## **Community Meeting Report for Rezoning Petition No. 2021-090**

**Petitioner:** APM Mallard Creek, LLC

**Rezoning Petition No.:** 2021-090

**Property:** 9925 & 10017 Mallard Creek Road, Charlotte, NC 28262

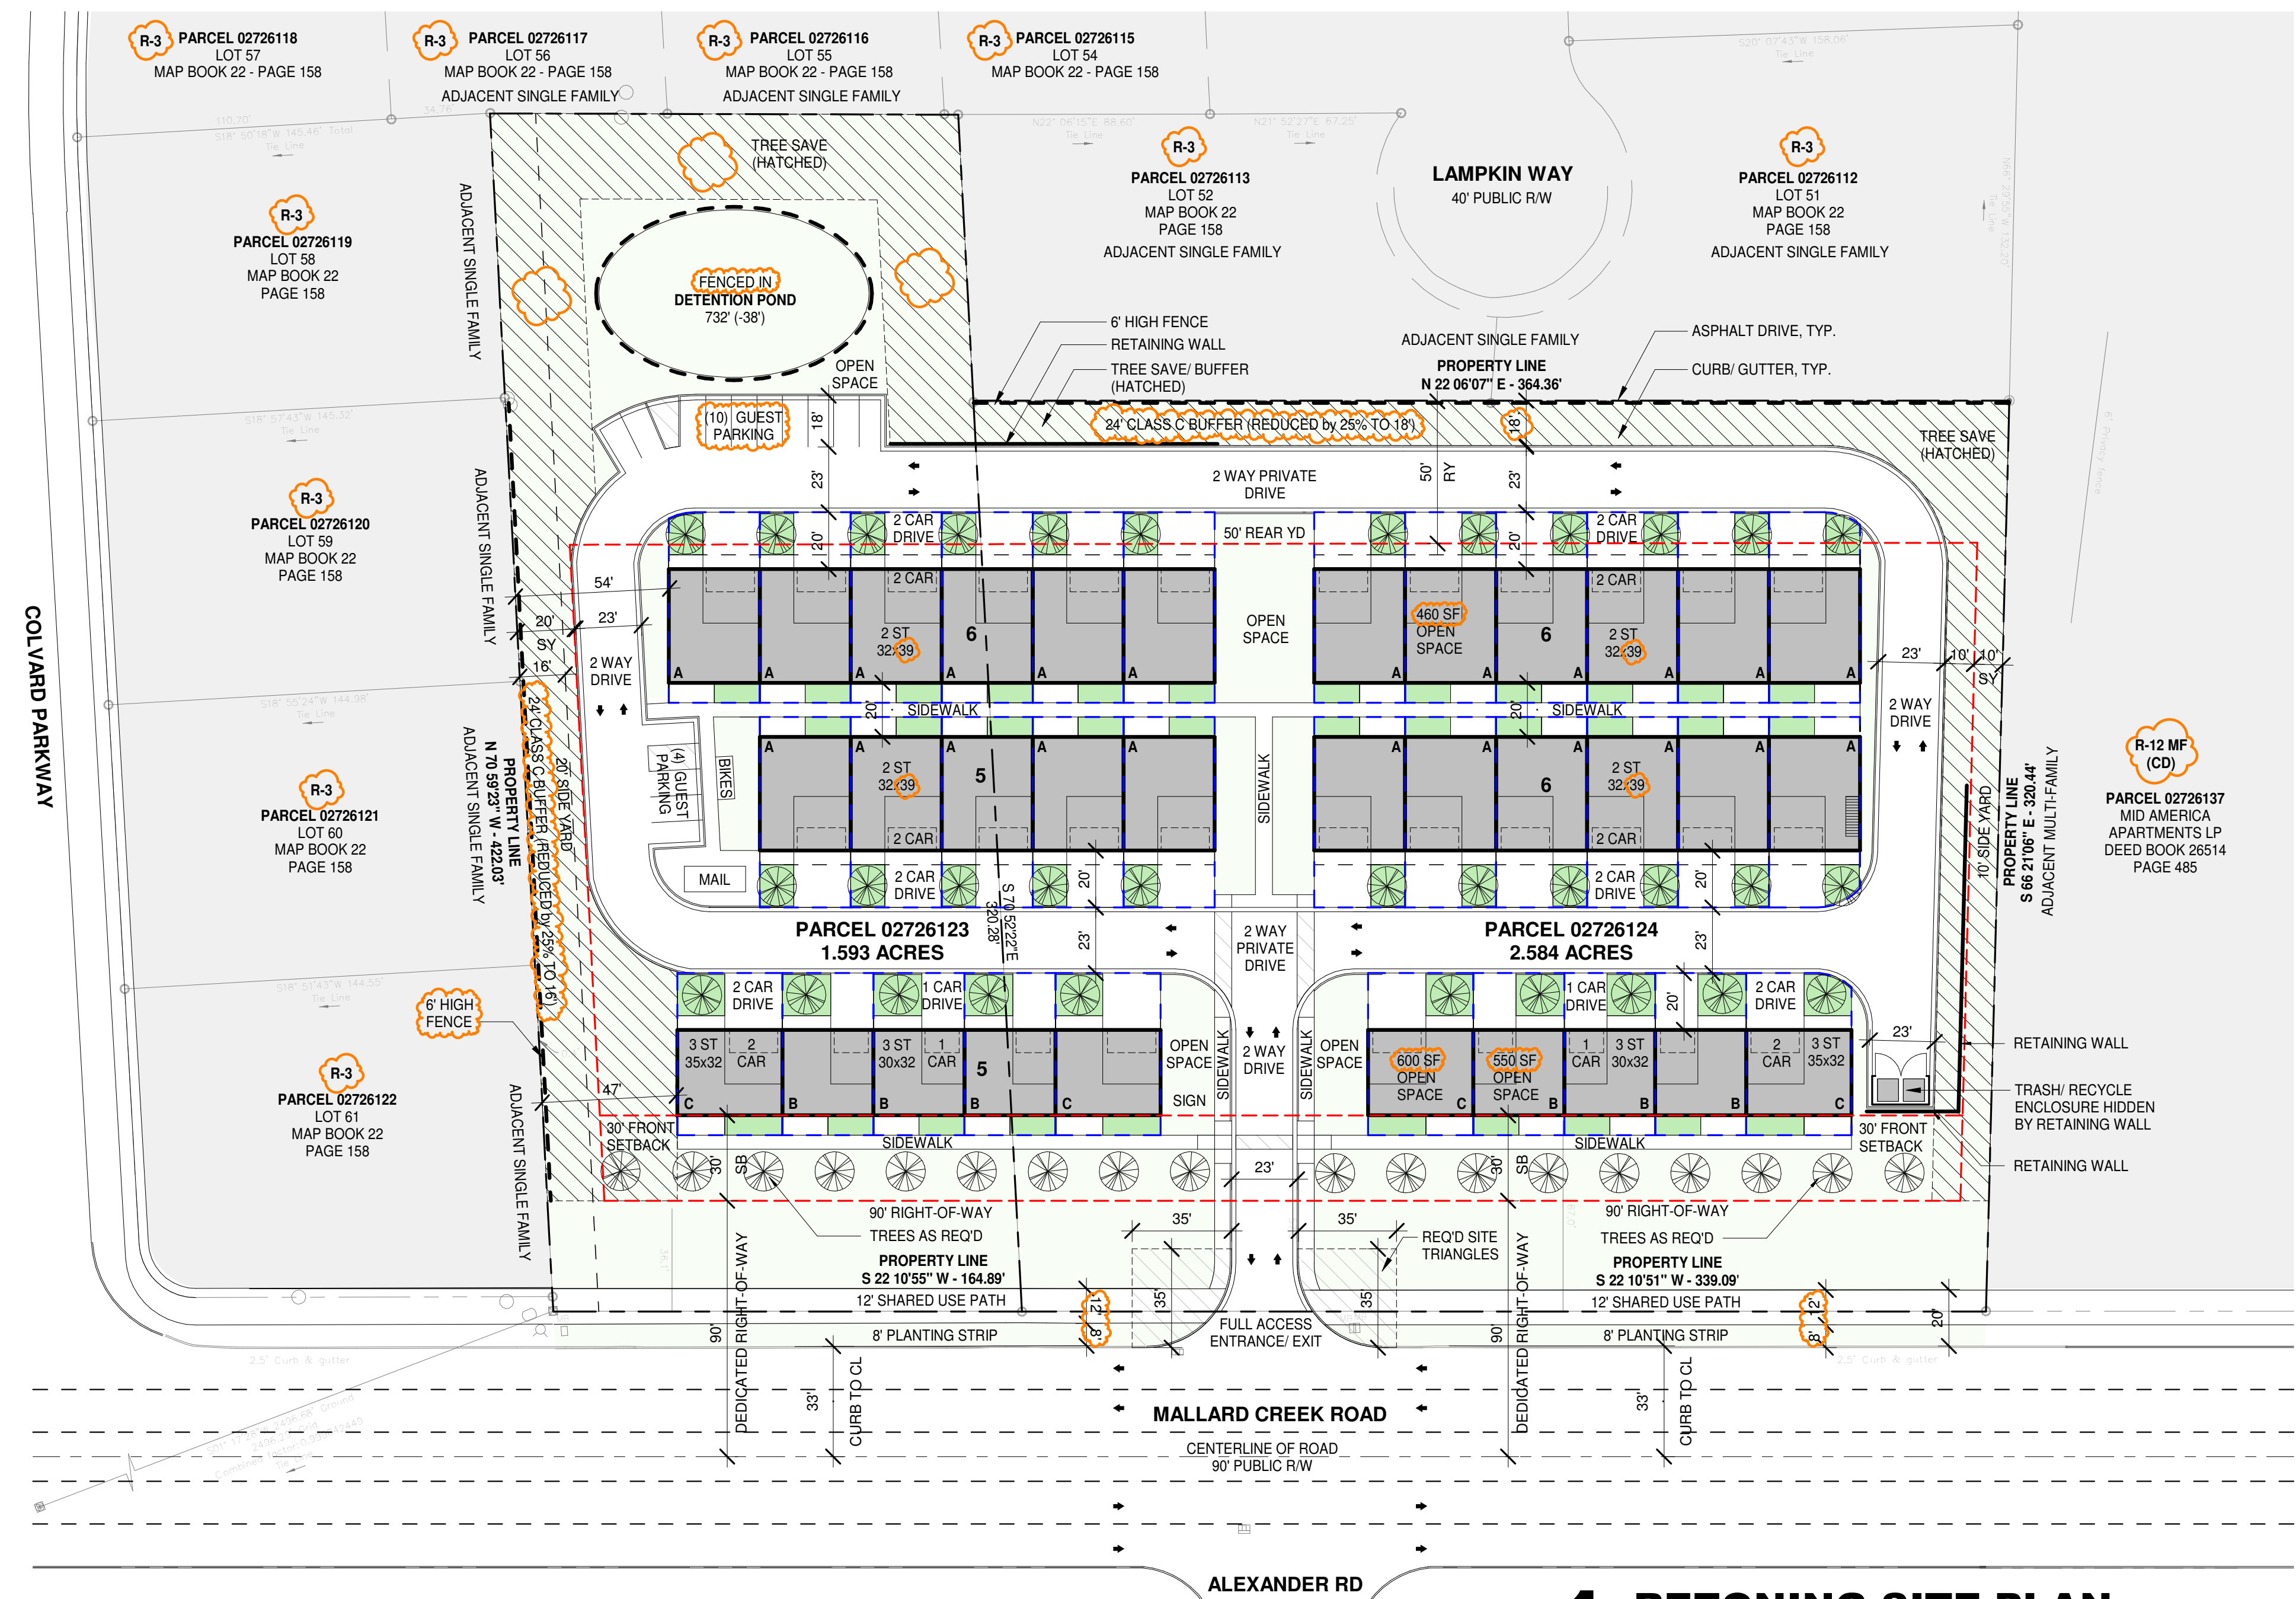
concerning the proposed six-foot privacy wall and its ability to effectively neutralize sound coming from the townhome development.

There were questions as to whether the site plan provided enough parking for both the residents and any guests they may have, and if visitors were unable to access parking within the townhome development would they merely park in the surrounding communities including Colvard Park. RAD Architecture responded by stating that the site plan generally allots four (4) parking spaces for each unit along with a guest parking pad that accounts for four (4) additional community spaces. Mrs. Tamara Howlett followed up with additional concern over the overall parking scheme for the development and noted that two townhome units within the site only appear to have two (2) parking spaces.

Mrs. Crystal McBride also expressed concern regarding the detention pond, specifically with neighborhood children playing in and around the detention pond and possibly being injured. RAD Architecture stated that generally the engineer of the community will ensure that the detention pond is fenced in, and moreover the proposed depth of the detention pond will be 6-8 feet and the site engineer will take the appropriate measures to keep the pond at that reasonable depth.

- To address concerns regarding the safety of the detention pond a fence will be constructed around the detention pond

- To address concerns regarding parking and development resident overflow the site plan will be revised to add 8-10 parking stalls head in facing the pond.
- The rear buffer will be increased from 12' to 18' per LD Zoning review comments and to address concerns regarding the rear buffer from those in attendance
- The following note will be added to the site plan to comply with Storm Water recommendations and address community concerns: "The location, size, and type of storm water management systems depicted on the Rezoning Plan are subject to review and approval as part of the full development plan submittal and are not implicitly approved with this rezoning. Adjustments may be necessary in order to accommodate actual storm water treatment requirements and natural site discharge points."
